From: Jennifer Thompson
To: Fraser, Jean
Date: 1/23/2014 7:29 AM
Subject: Re: 133 York Street Plat and Condo Docs

Jean - I agree with your assessment. The Plat and the condo docs for this application are marginal. Although I realize that the practice has, somewhat by necessity, been to make final edits to the plat and condo docs a condition of approval, there is still a requirement that applications for subdivision approval be complete when they go before the Board and that the proposed plat and condo docs contain sufficient detail to allow the Board to make an informed decision. As you say, for this one the plat and in condo docs need to clear in respect to:

**SUBDIVISION RECORDING PLAT**

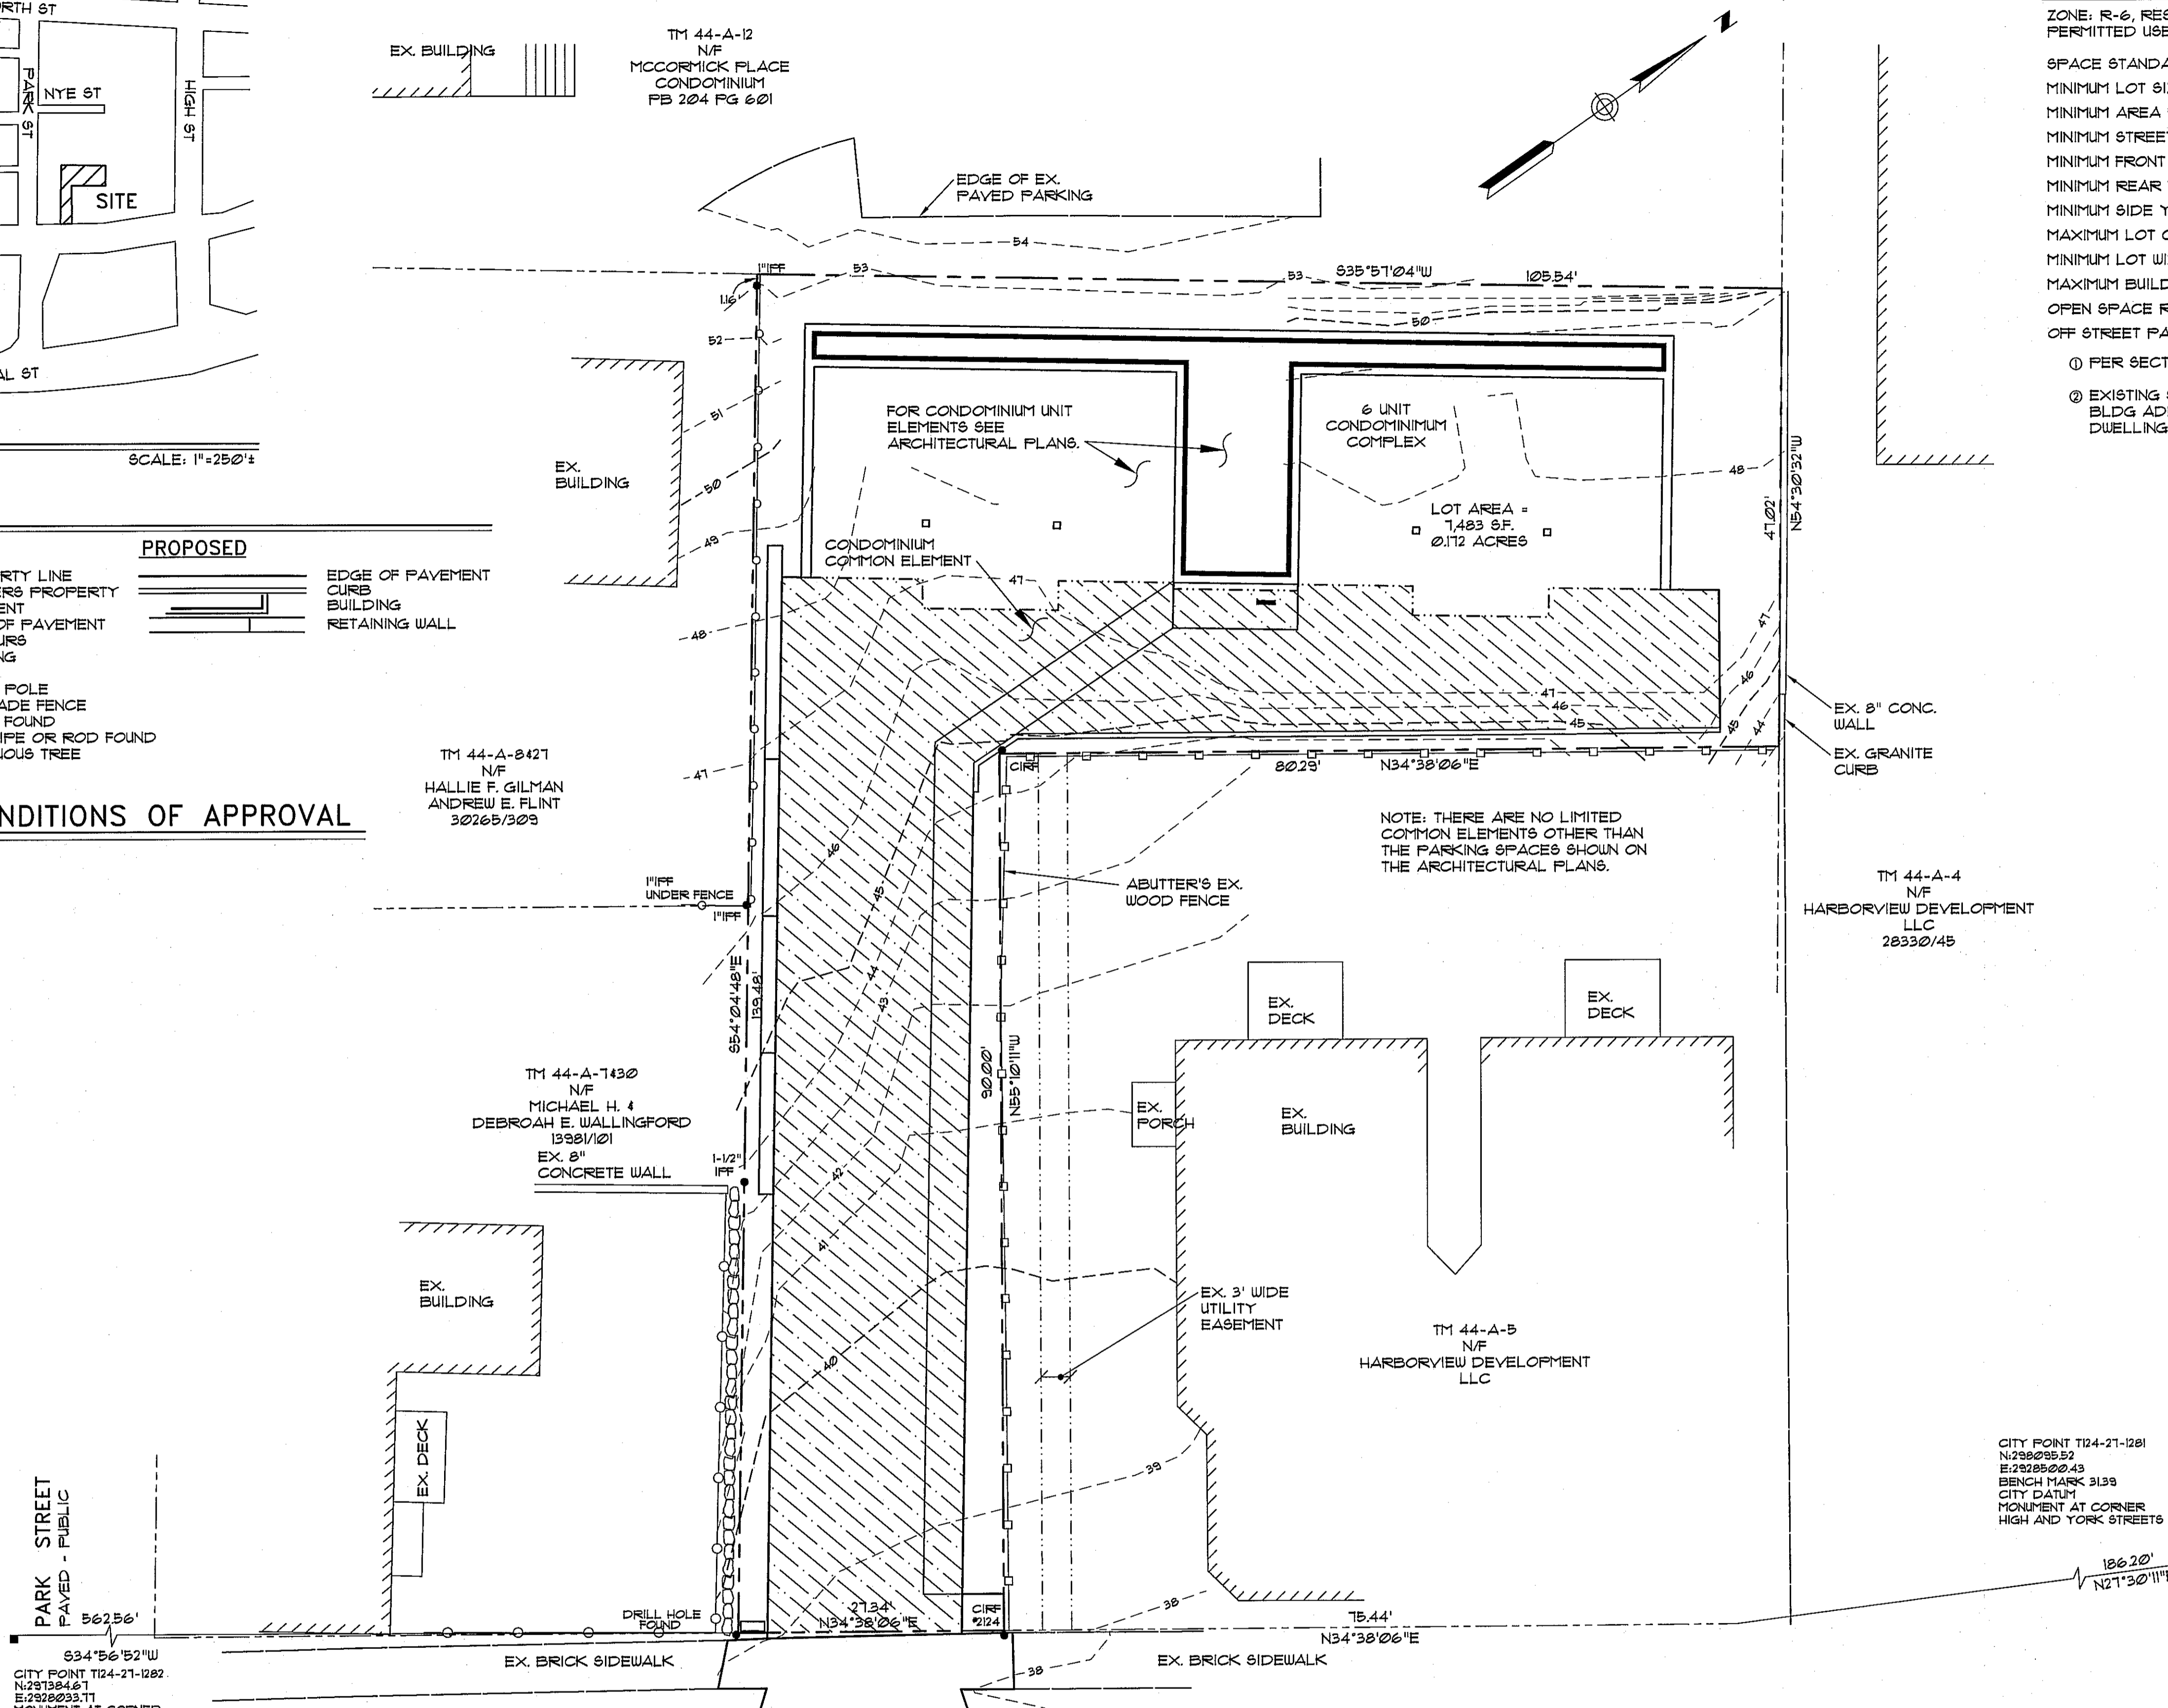
snow clearance requirements

Maintenance requirements

Existing utilities

location and purpose of pedestrian walkway between York and the front door

tree preservation measures (ongoing- maybe also during construction?)

location of tree filter and ref stormwater system maintenance (confirming that this is not city and referring to agreement etc)

Agreement re fencing with York Street apartments (see draft attached)

Plat should show street trees

I would also prefer to see the construction easements depicted.

The subdivision plat really needs to inform folks of necessary information on its face. It is not sufficient to be incorporating by reference other sheets when it comes to the essential contents of the plat.
